MP05_0038-MOD-1, RURAL RESIDENTIAL SUBDIVISION – MODIFICATION 1, LOT: 542 DP: 1113791, LOT: 156 DP: 753202 AND LOT: 53 DP: 836998, THE BUCKETTS WAY, TINONEE

Major Project modification - Tinonee Residential Subdivision

Mod to Tinonee PA (MP 05_0038 MOD 1) - Amended subdivision layout (MP05_0038-Mod-1)

**Tinonee Residential Subdivision (MP 05_0038 MOD 1)
Modification Report**

CARTERS CREEK ROAD GENERAL ARRANGEMENT PLAN
SCALE 1:500

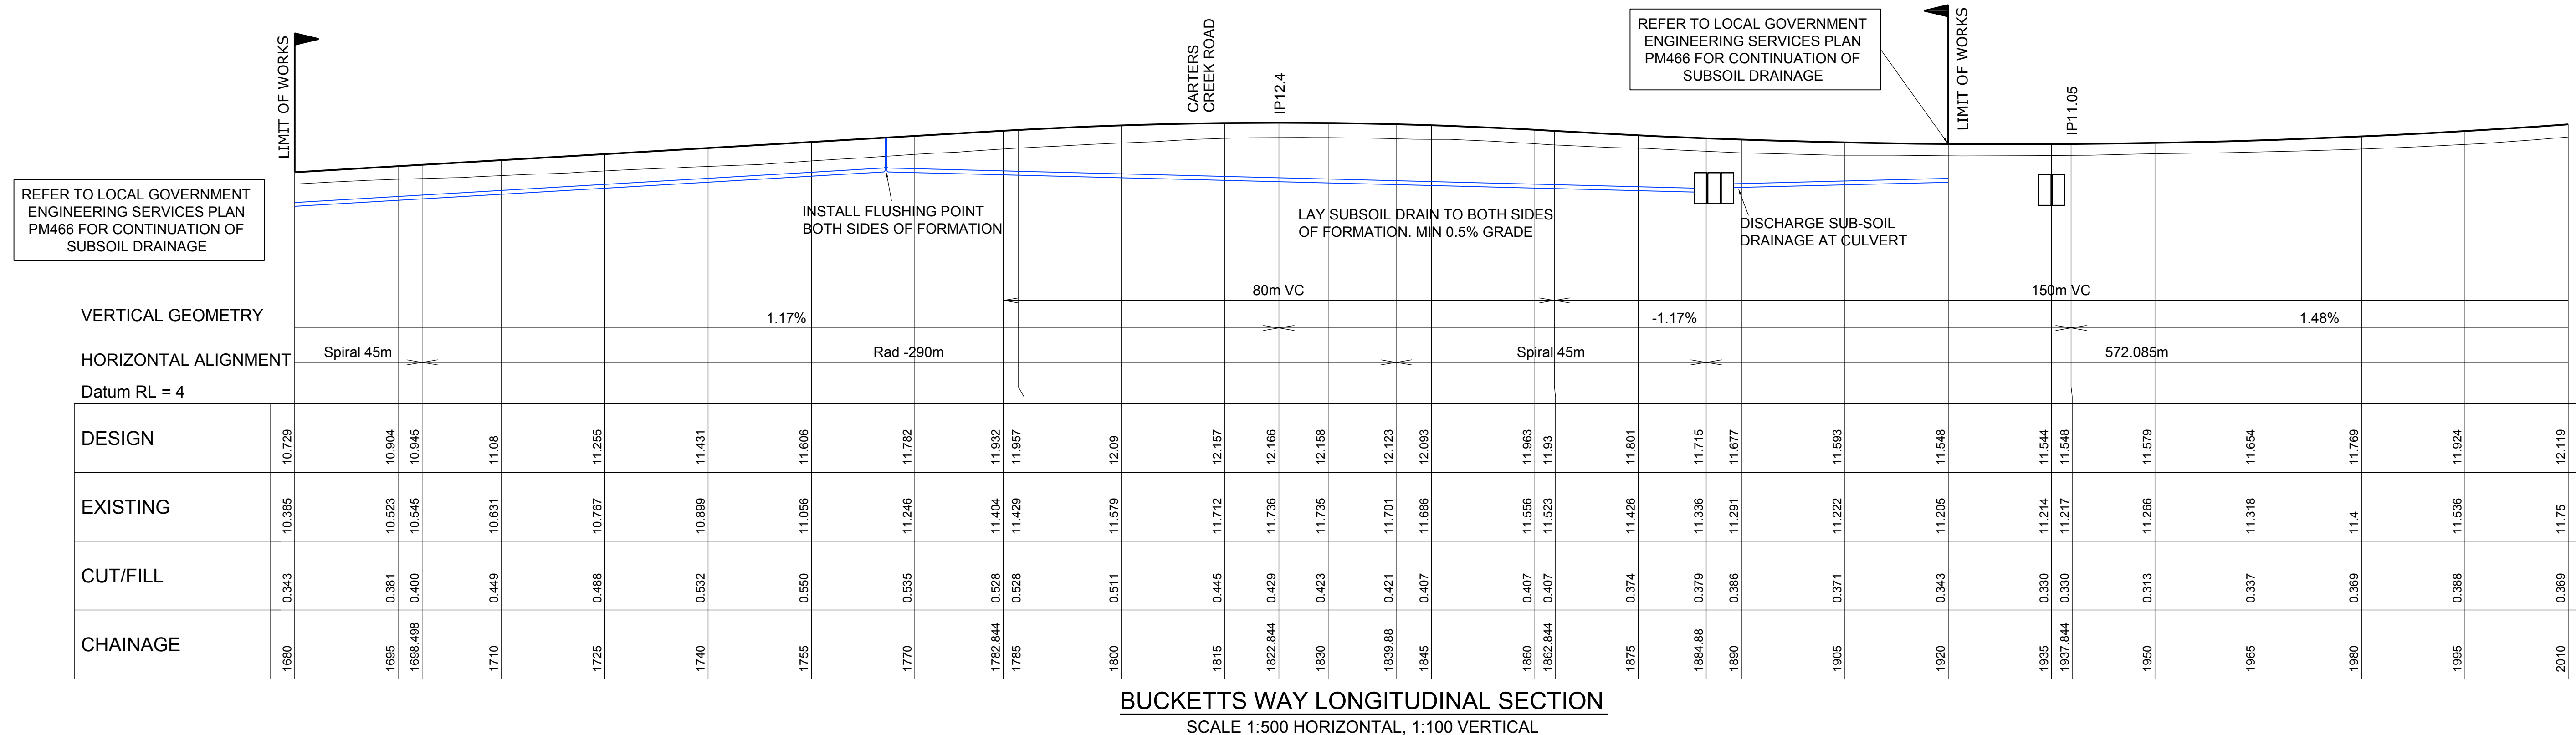
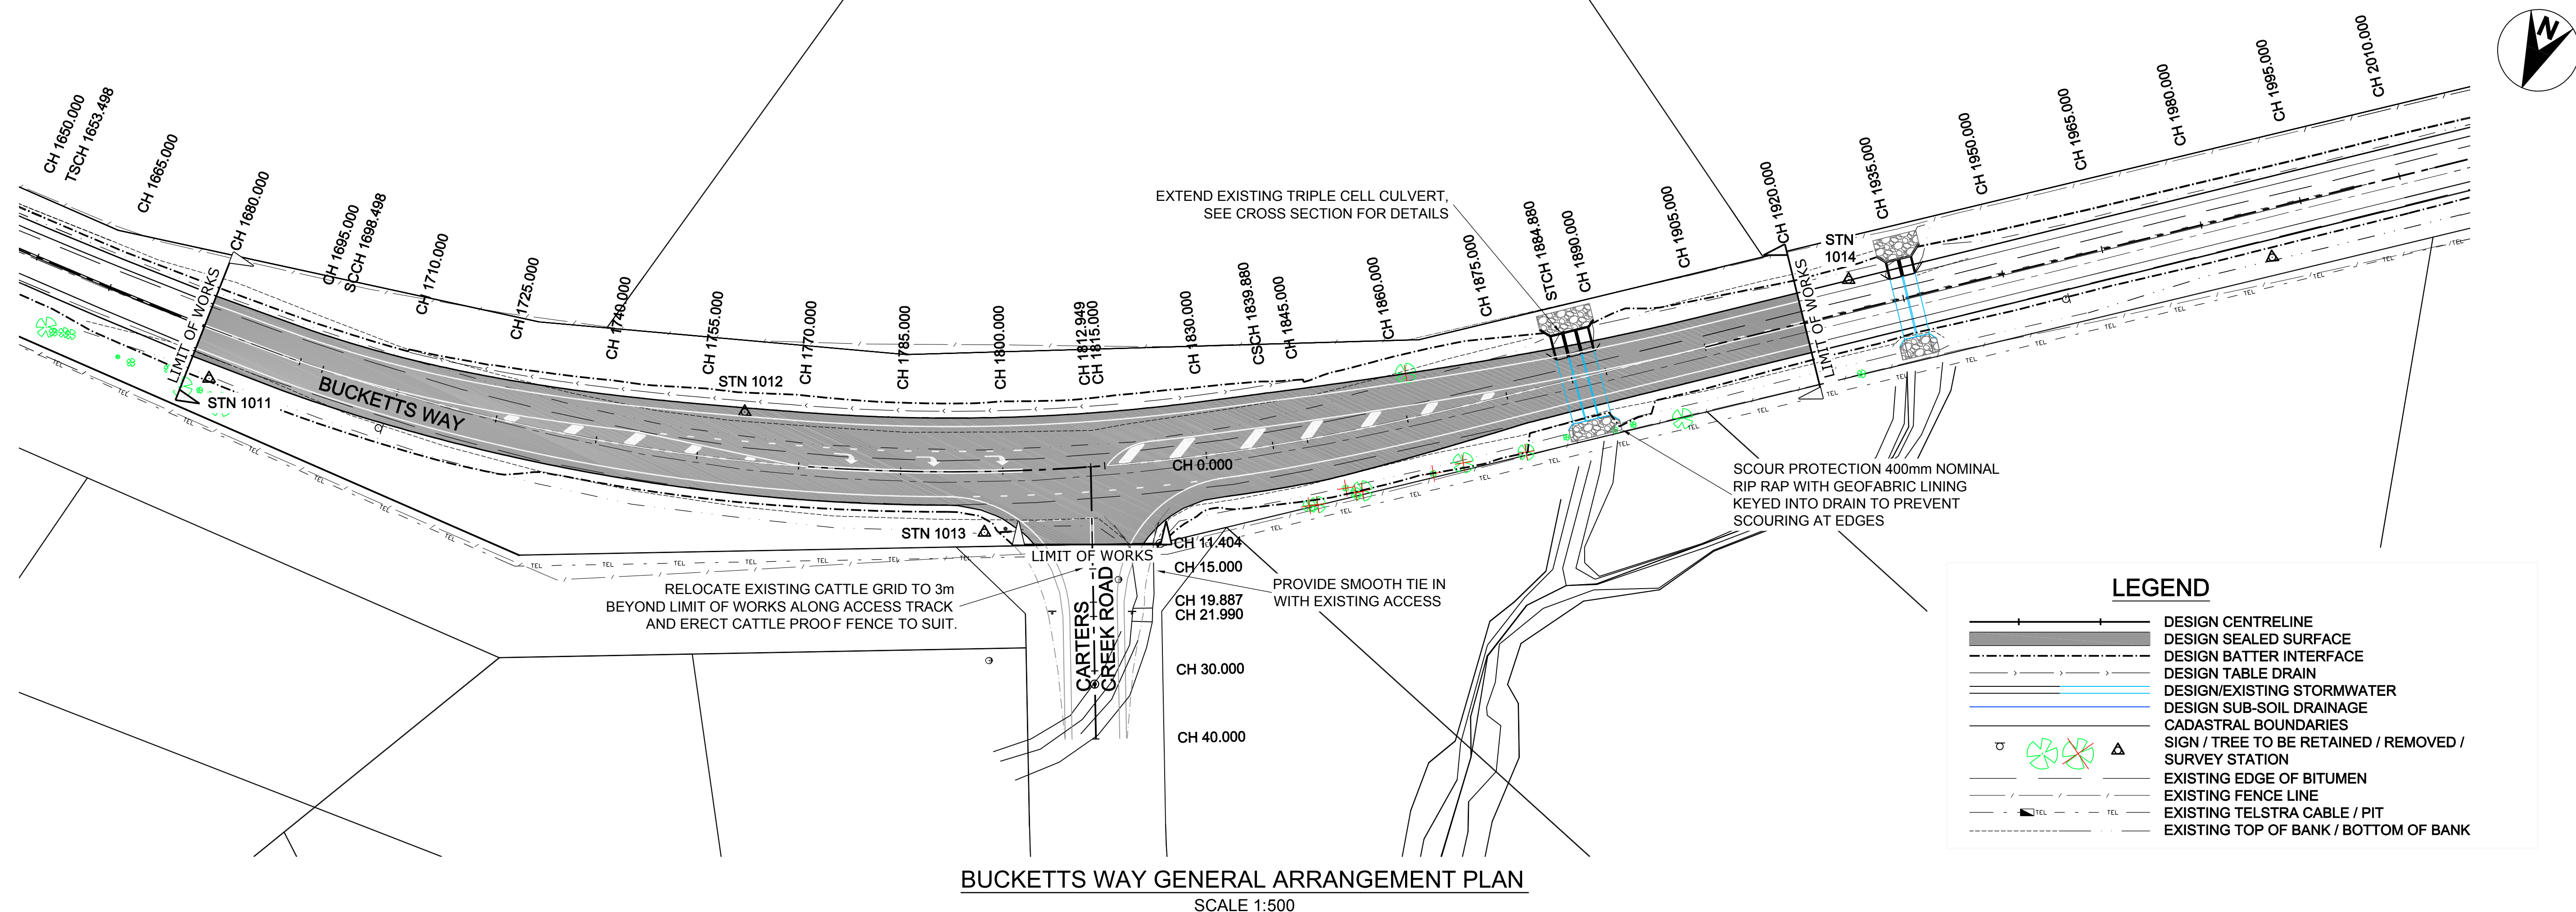
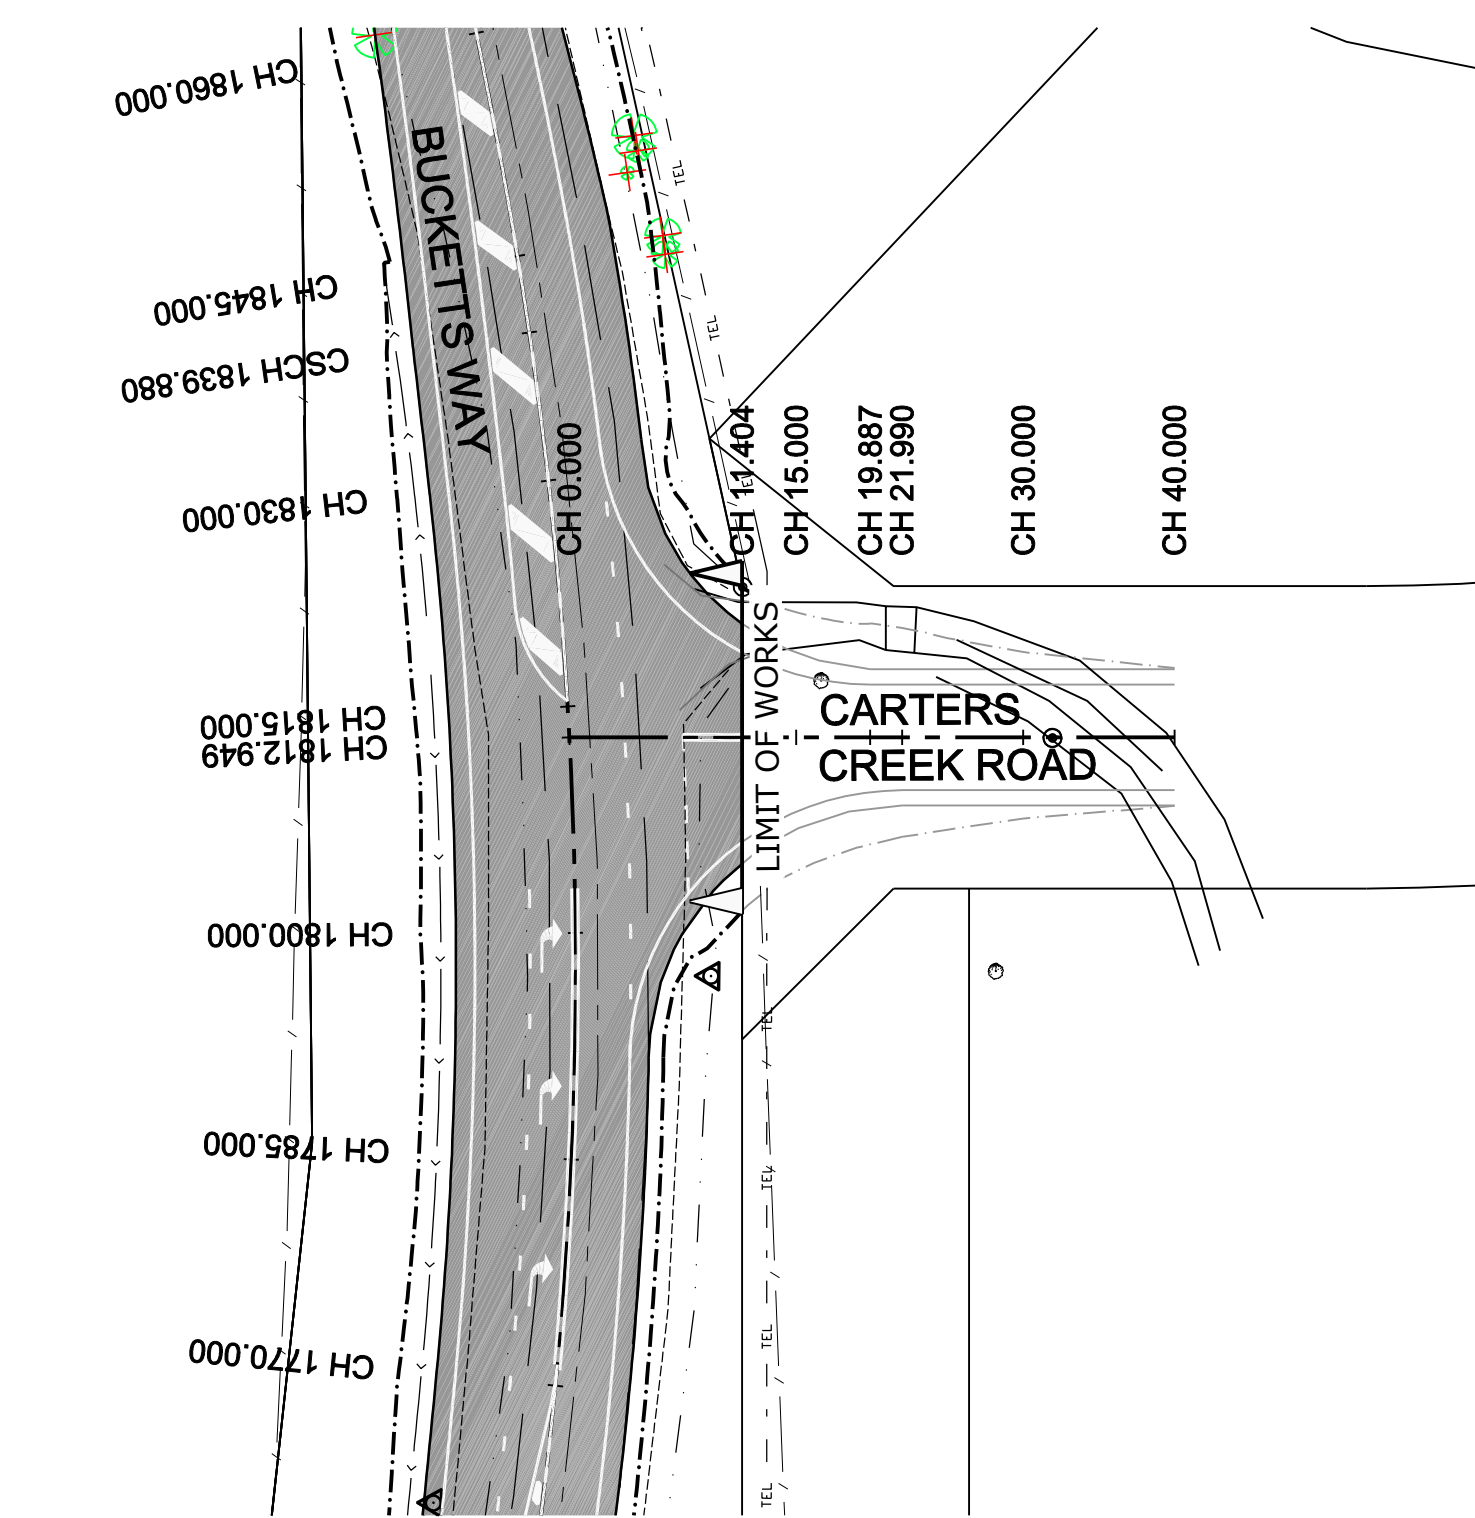
- TfNSW notes condition 'E35 (2) – Civil Works' of the current approval (MP05_0038) requires Channelised Right-Turn (CHR) / Basic Left-turn (BAL) treatments on The Bucketts Way intersections with the proposed subdivision main entry road and Urray Road. The intersection treatments were conditioned upon consideration of previous TfNSW (then RTA) response letters dated 3 July 2008 and 13 September 2007.

- The proposed modification report however appears to nominate an Auxiliary Right-Turn (AUR) intersection treatment noting the minor reduction in the number of proposed lots. TfNSW highlights that RMS Supplement to Austroads Guide to Road Design Part 4A (RMS17.336, Version 2.1, dated 31 August 2017) does not permit the use of an AUR treatment in NSW.

- TfNSW advises that The Bucketts Way is now classified as a local road, unlike a classified Regional road at the time of previous TfNSW responses. The intersection treatments on The Bucketts Way is therefore a matter of consideration for MidCoast Council (Council).

It is recommended that Council determines the required intersection treatments in accordance with *Austroads Guide to Traffic Management Part 6: Intersections, Interchanges and Crossings (2020)*.

PROPOSED SUBDIVISION STAGE 2 ILLIDGE ESTATE

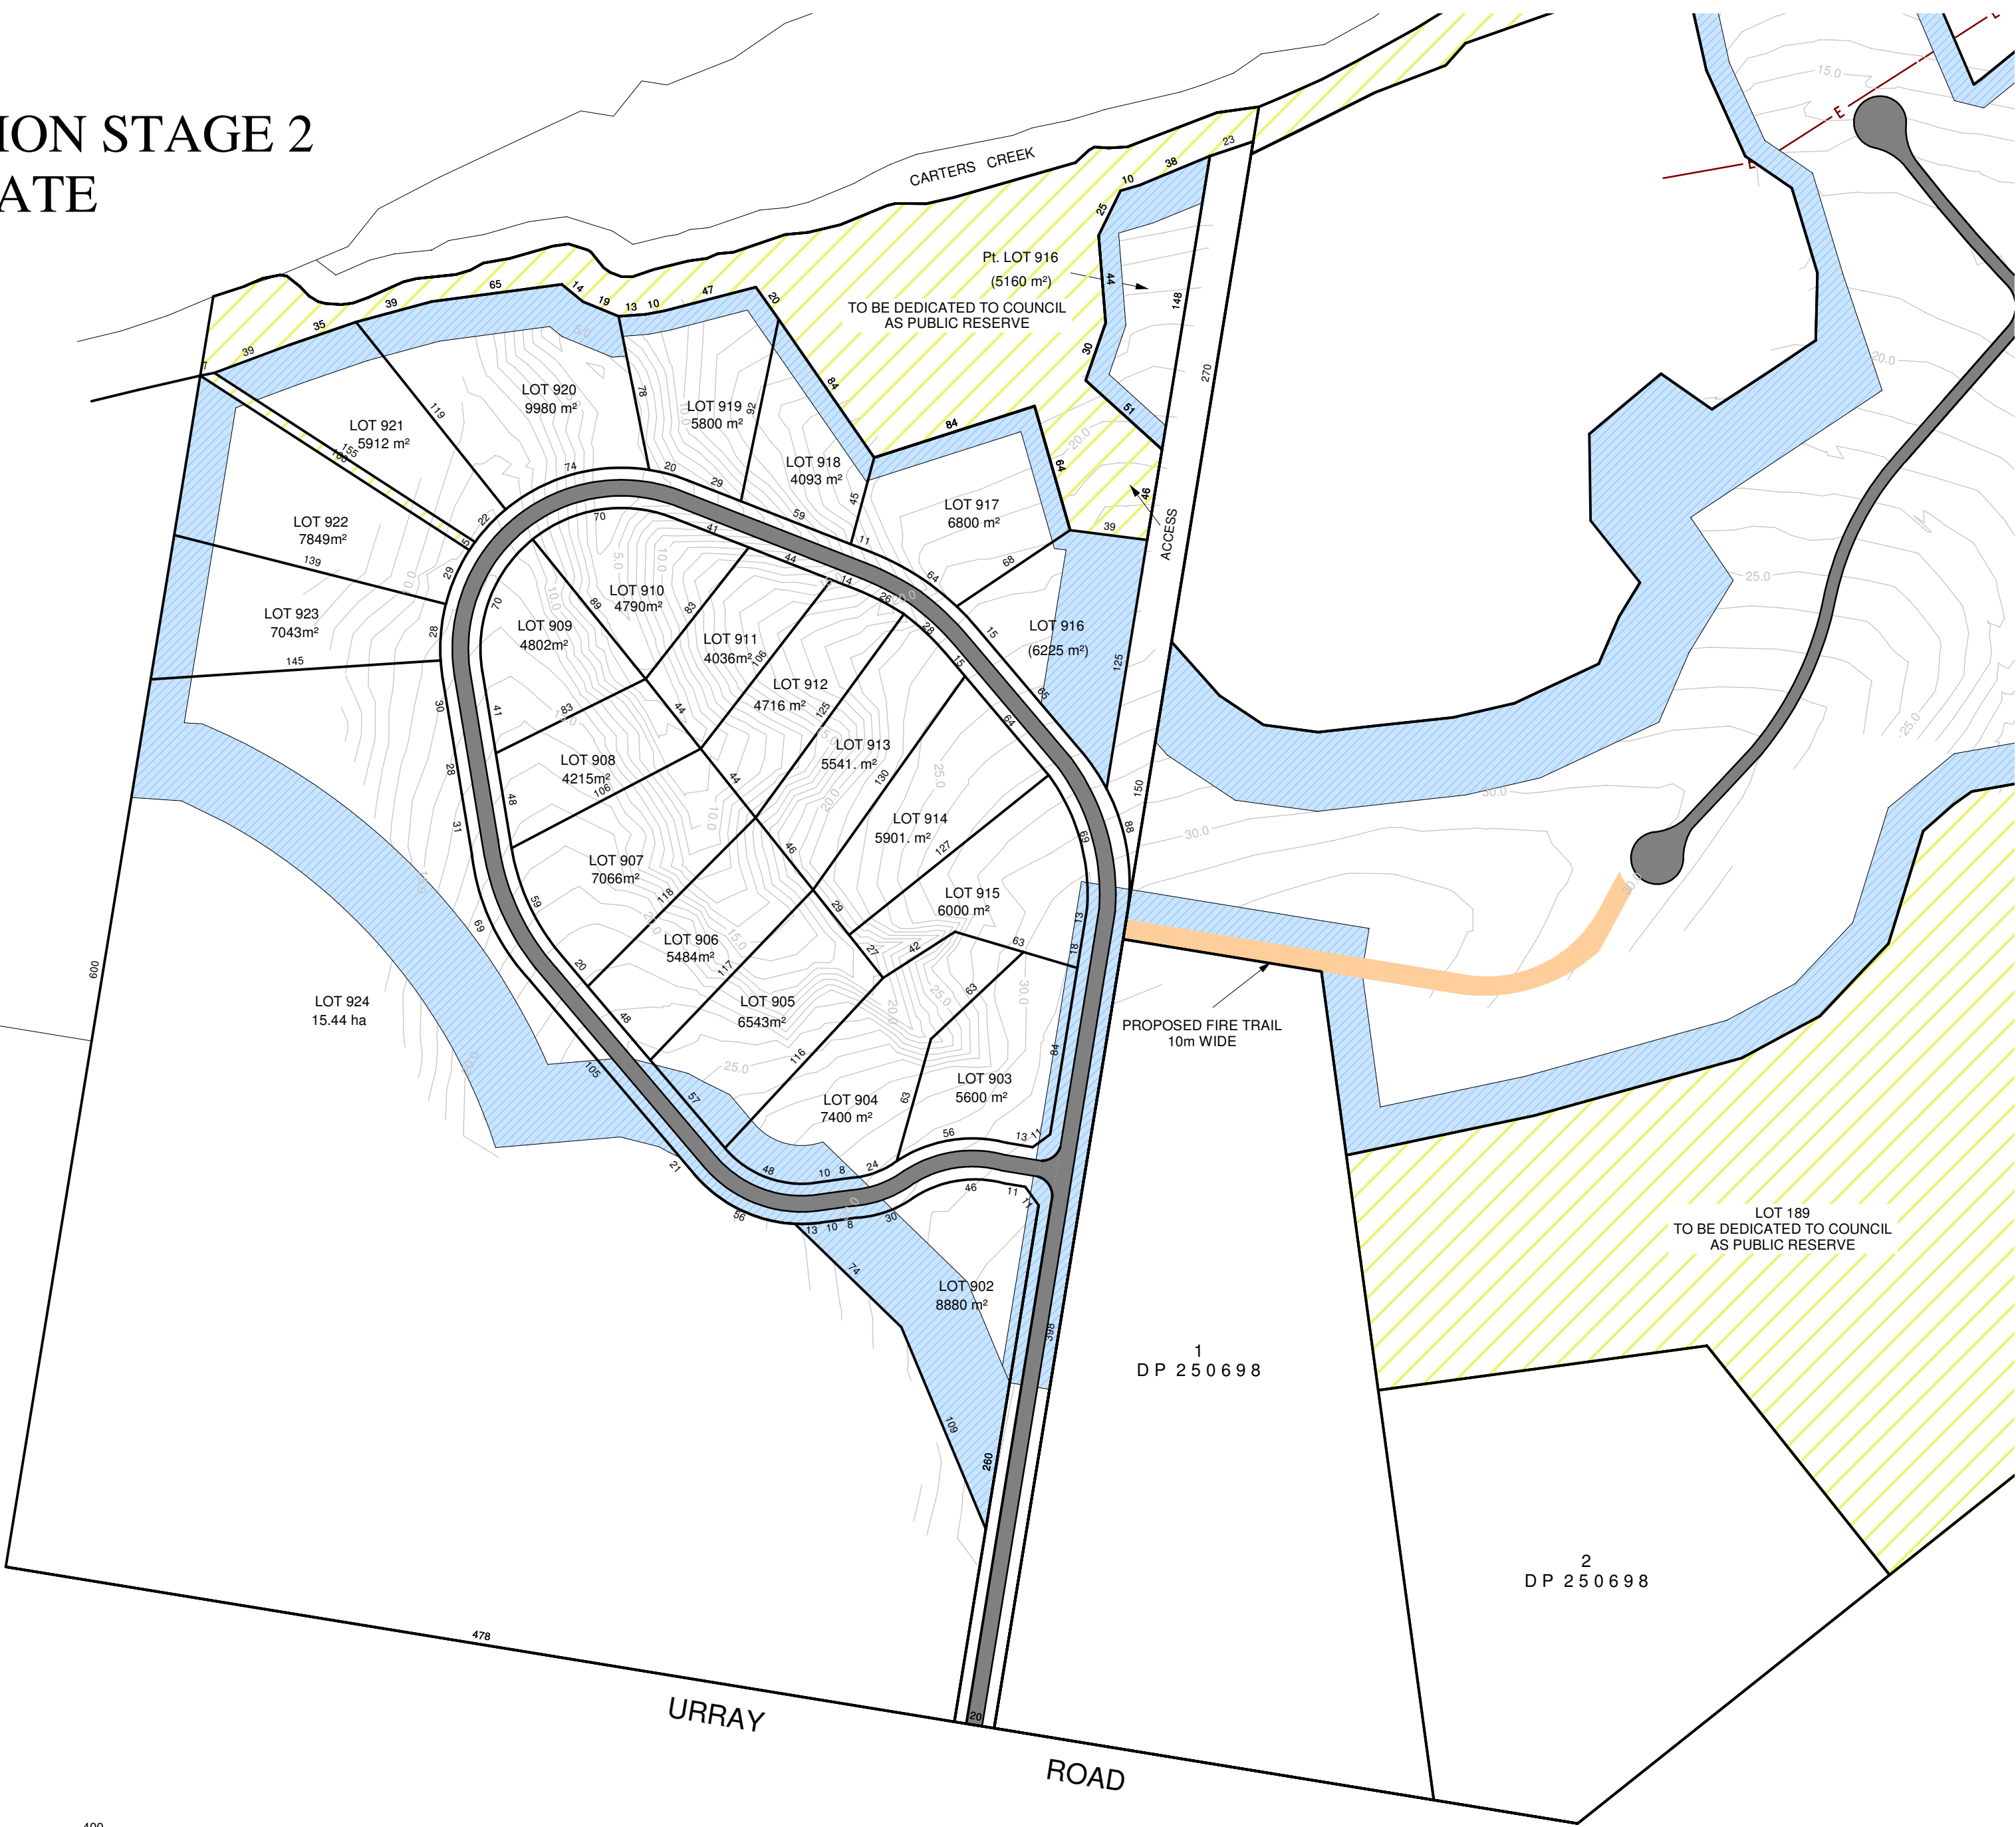
- The amended plans provide additional lots over 916 / 917 and 924. In our opinion, there is inadequate justification provided for these lots. The proposed Lot 917 appears to be divided into two separate areas. This appears impractical. The northern part of proposed Lot 917 should be deleted and incorporated into the dedicated public foreshore reserve.

There is no public foreshore reserve proposed to be created on in Stage 3 over certain parts of proposed Lots 332, 333 and 334 (and in the same manner in which the public foreshore reserve is provided for within the Stage 2 lands). This needs to be rectified.
